DRB CASE ACTION LOG (FINAL PLAT)

DRB Application No.: 06DRB-01200 (FP)

Project # 1002184

Project Name: LANDS OF RAYMOND & CARMEN DIMAS

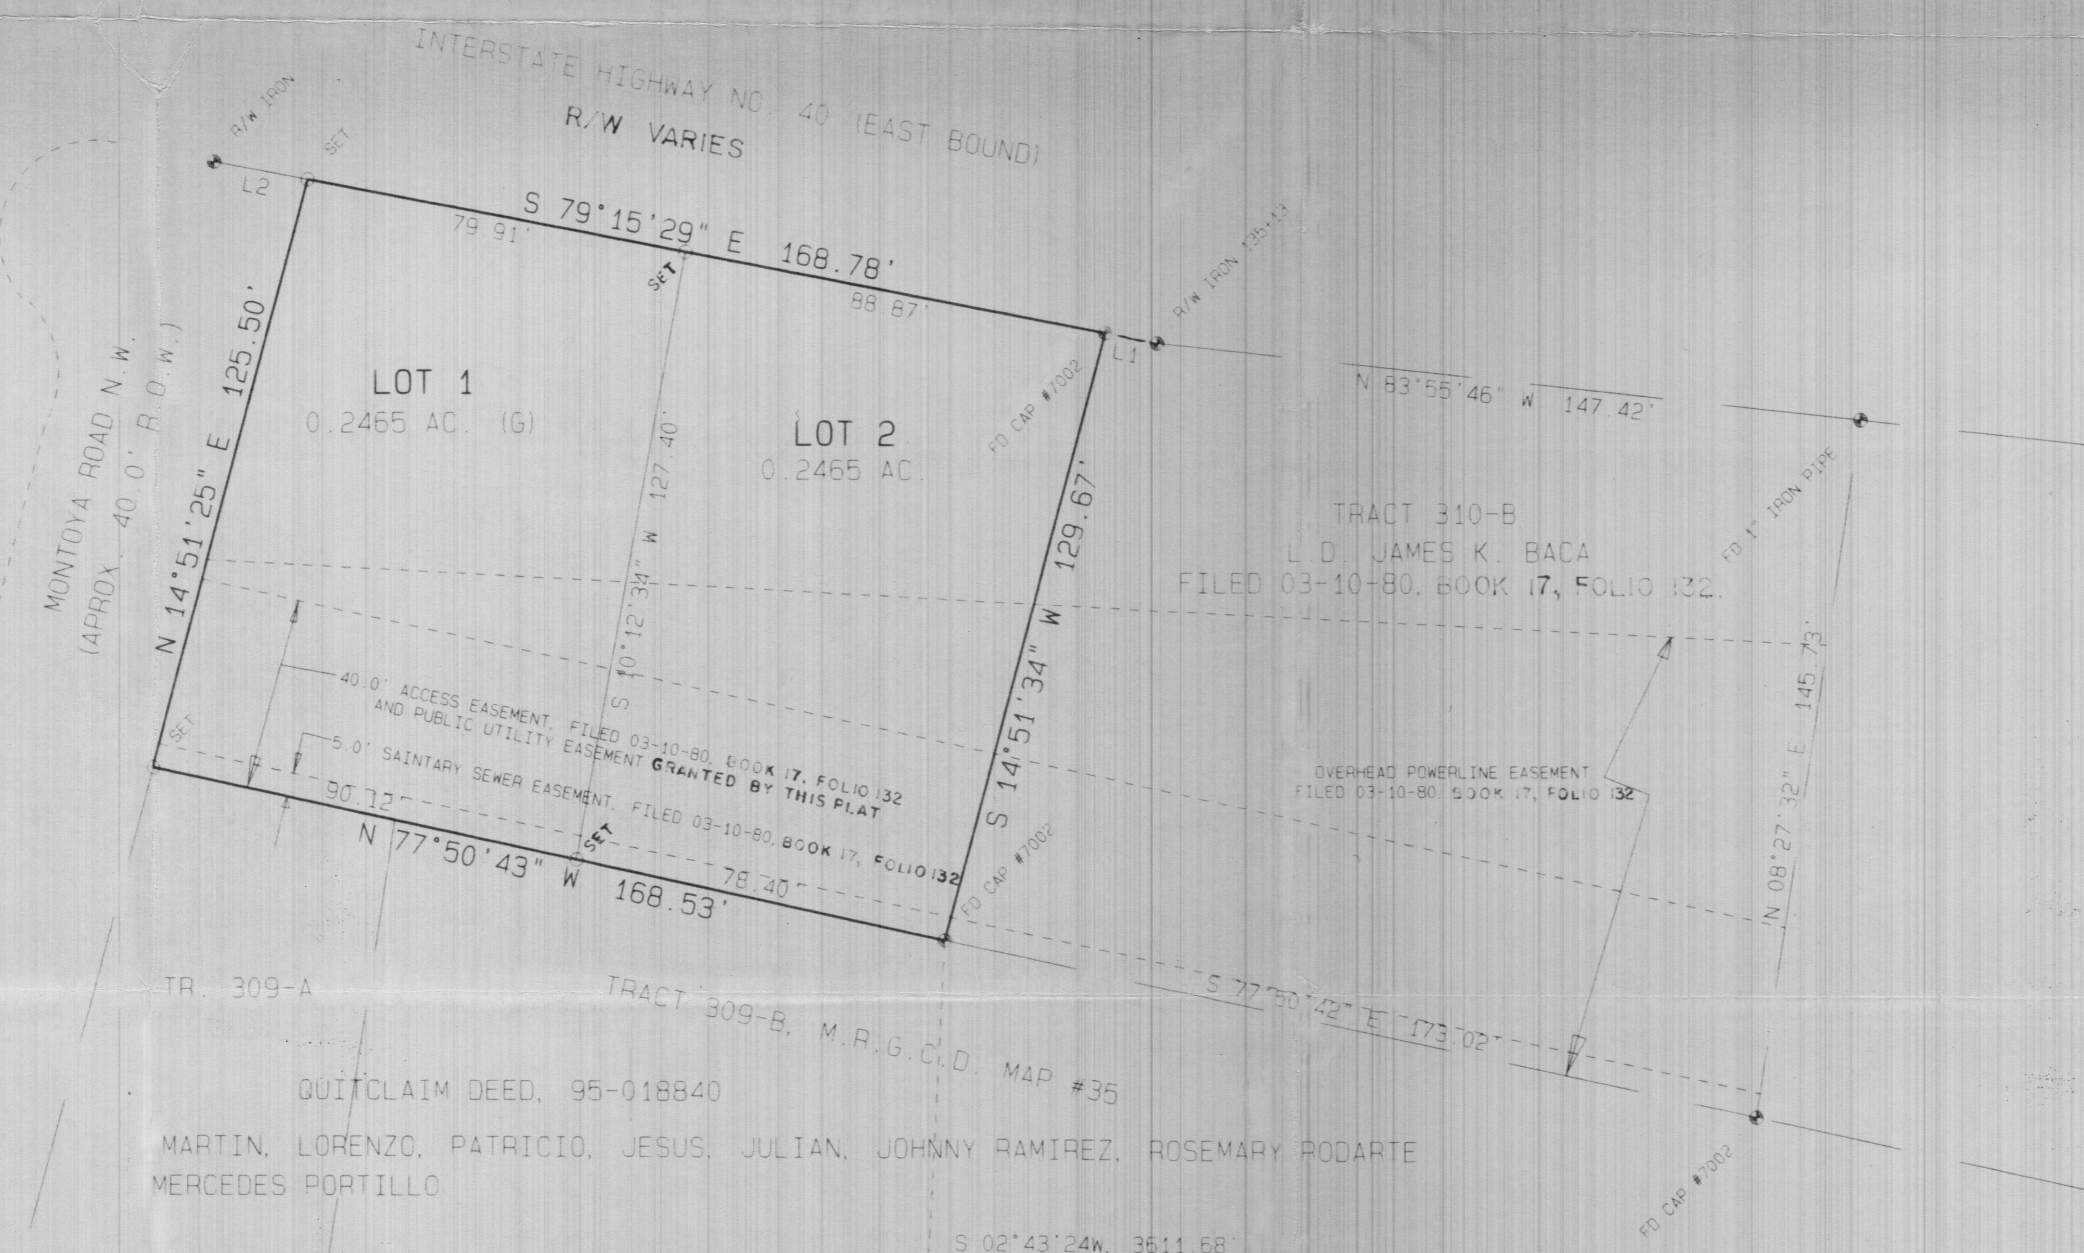
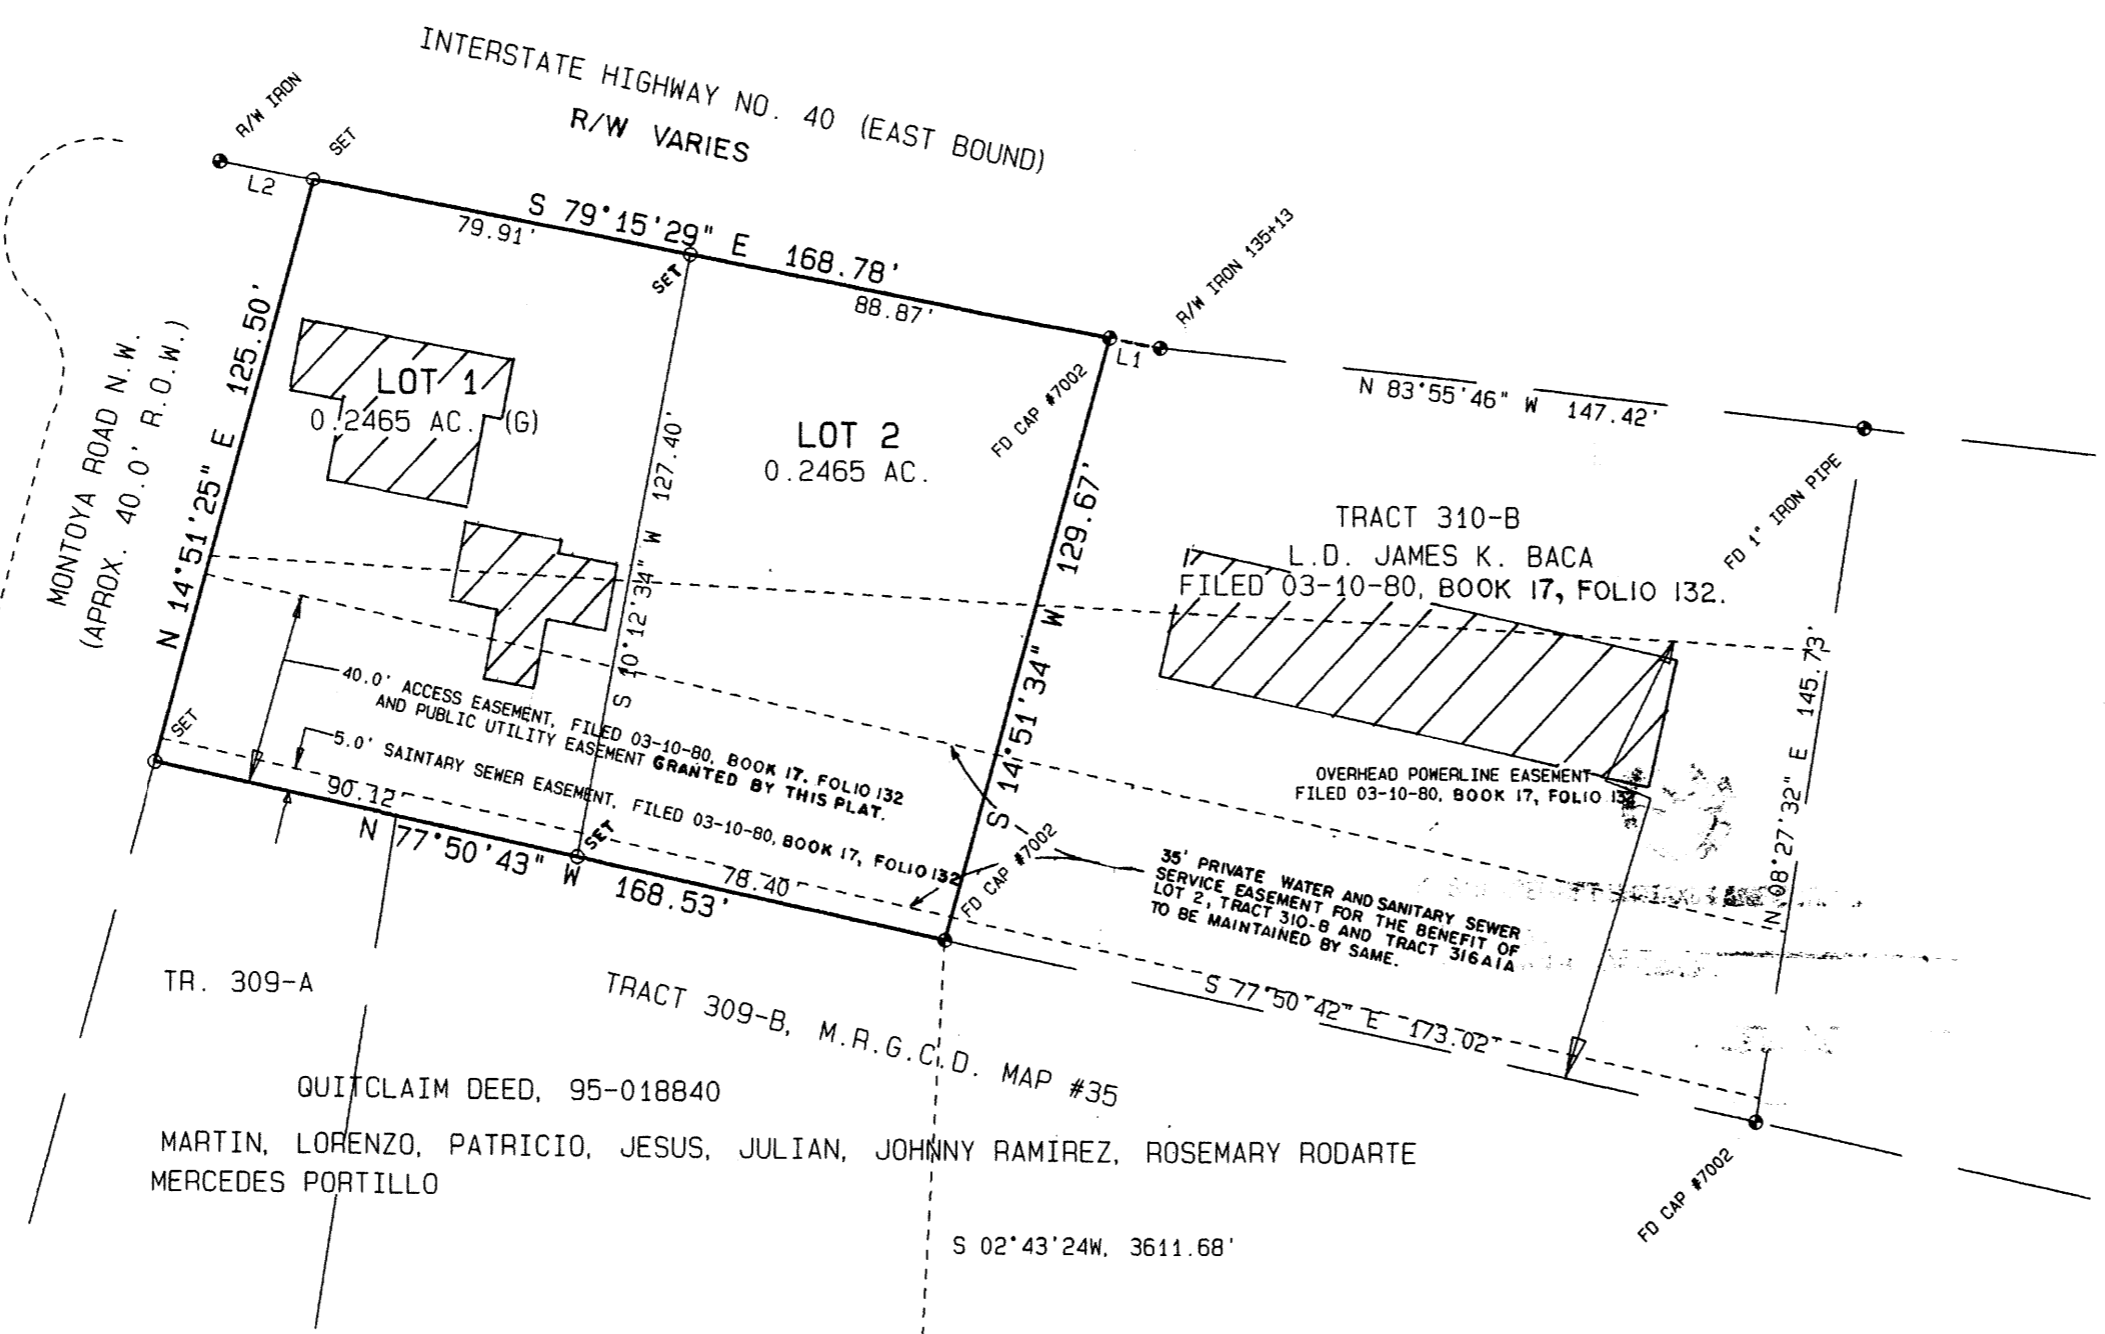
UTILITY DEV (505) 924-3989			
PLANS DISAPPROVED	RP	DATE	2/5/03
PLANS APPROVED	RP	DATE	6/27/03
COMMENTS:			
✓ Need to dedicate "Private water and sewer service easement" for the benefit of Lot 2, Tract 310-B, and Tract 316A1A.			
✓ Need to Clarify what is "Granted by this Plat" and move new Private easement over to Lots 1 & 2 and say "Granted by this Plat".			
Outline of Structures should be on separate sheet.

1. Must have easement dedicated for existing private water service that serves 1118 Montoya (Lot 310B)

2. Normally we would require a public water line extension and dedicated easement 20' wide to serve Lot 316A1A to the east. I may be willing to waive this if Lot 316A1A agrees to paying for a new water meter located in Montoya Road.
